Online Comment

Application H16-1056-23
Location CASTLEBUILD SCAFFOLDING HOLBEACH ROAD SPALDING PE12 6JP
Proposal Proposed extension to existing site to include 8 storage units under corrugated roof with PV panels and erection of 3 Koda Pods

Name Diane Gordon
Address SHDC Environmental Protection

Date Submitted 02-02-24
For/Against Comments

Scheme	
3no KODA UNITS AT HOLBEACH ROAD, SPALDING FOR CASTLEBUILD SCAFFOLDING	
Title	
BLOCK ELEVATION AND PLANS	
Drawing No	SD/01
Scale	1:100 @ A3
Date	10:11:23

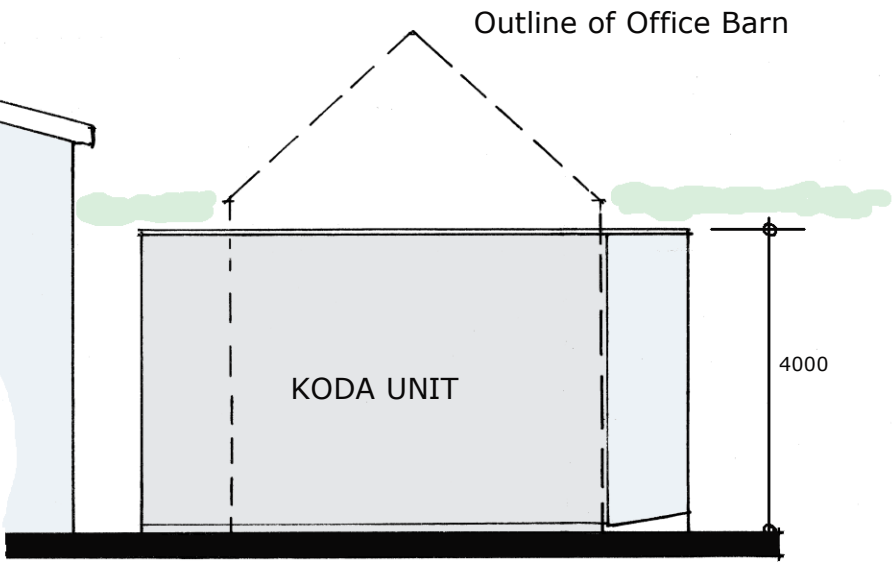
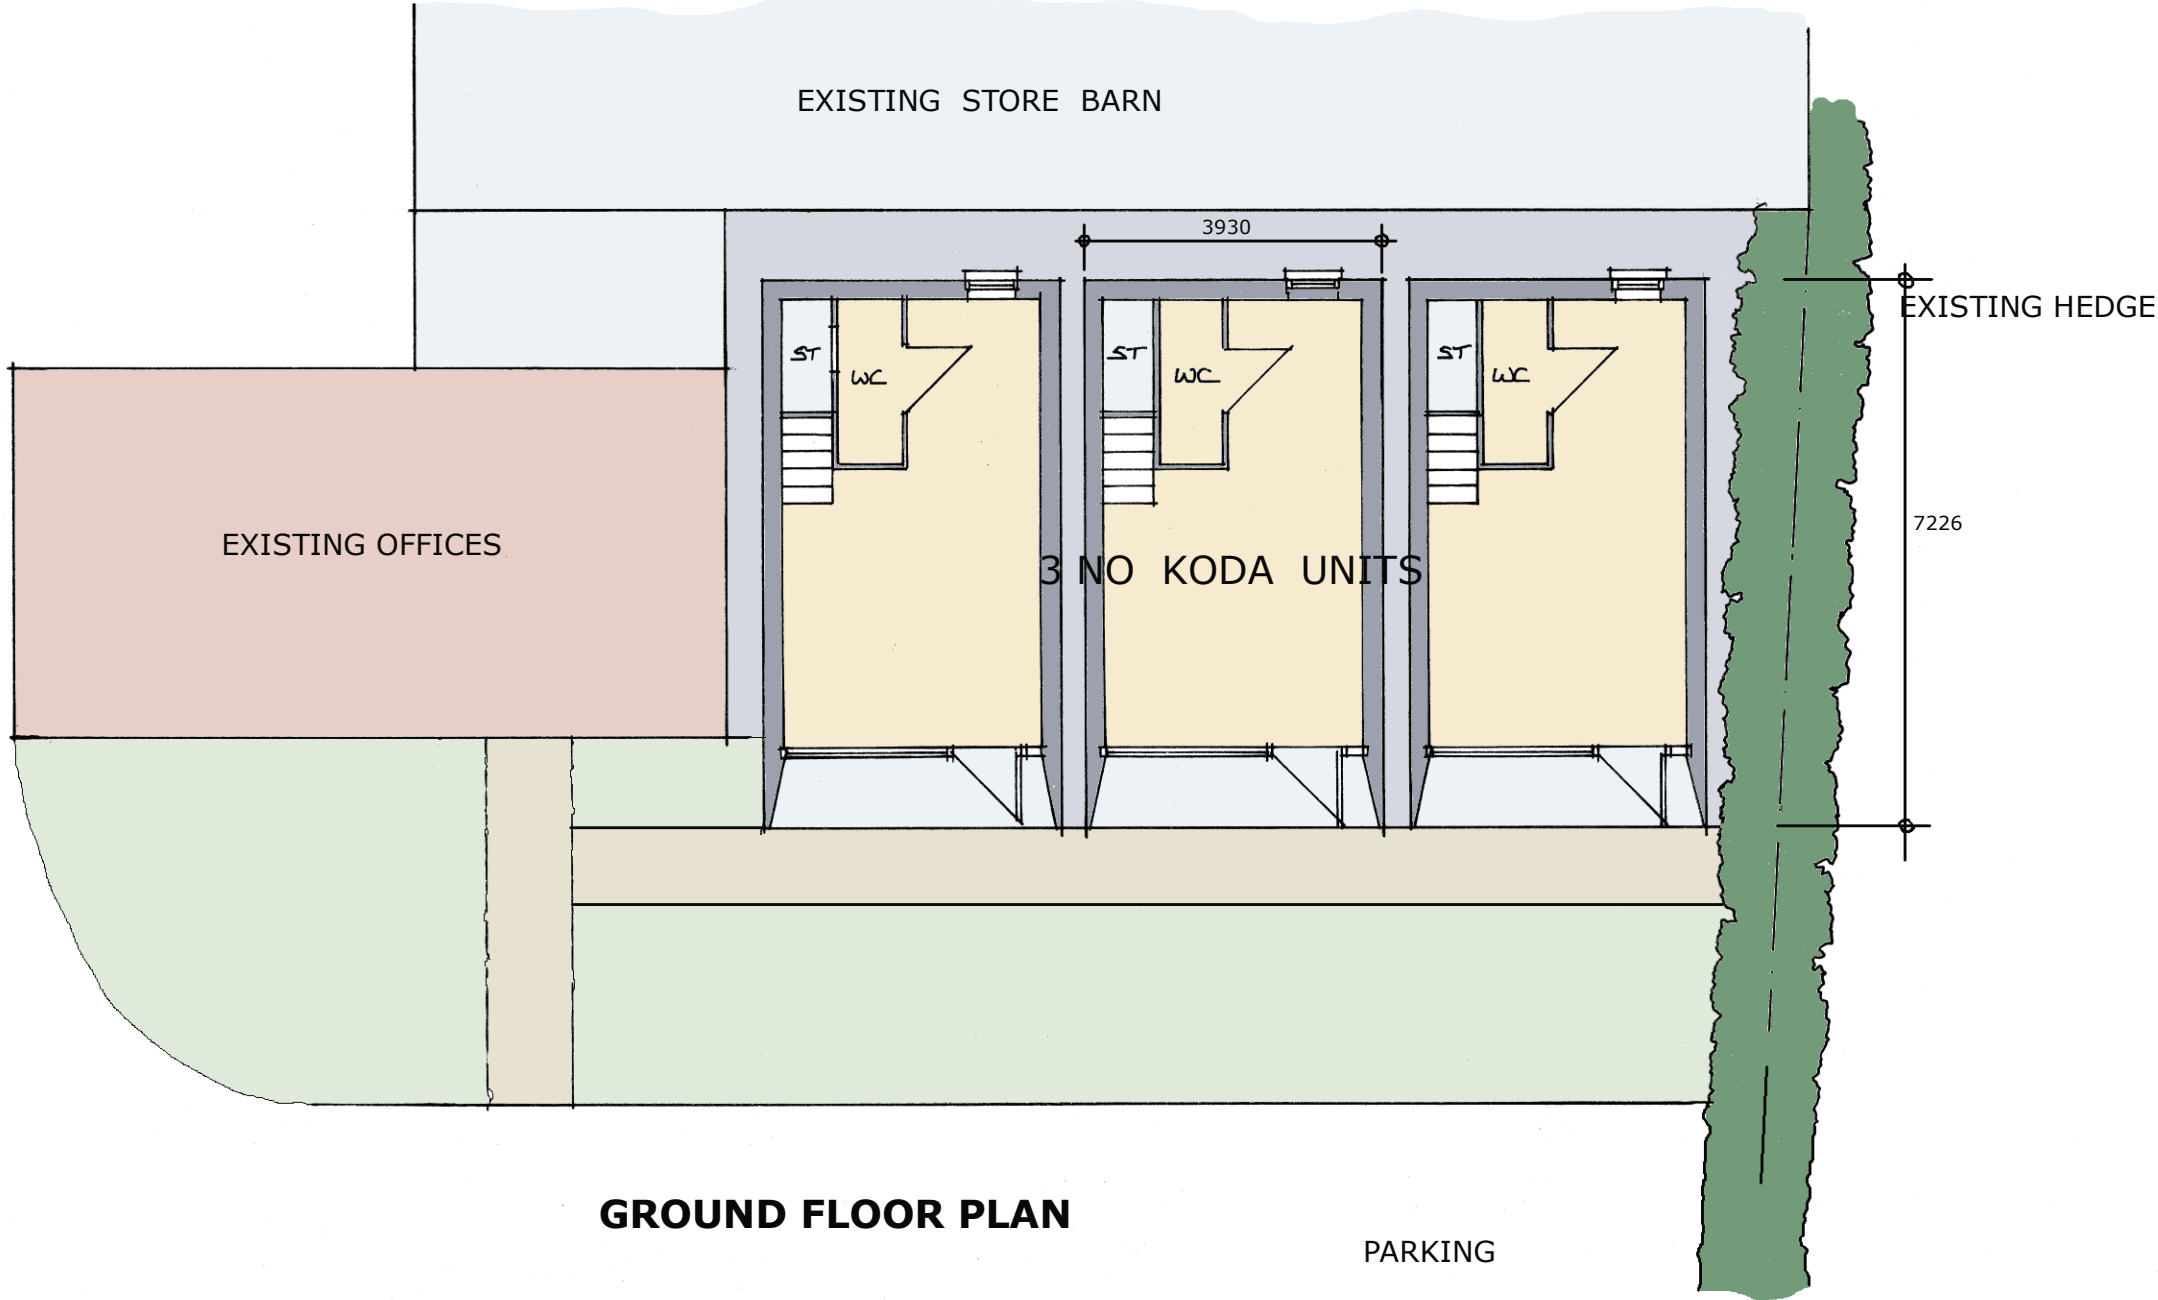
the use of the KODA pods should be restricted to office/meeting space or use of a similar nature.
to protect amenity of nearby residential properties
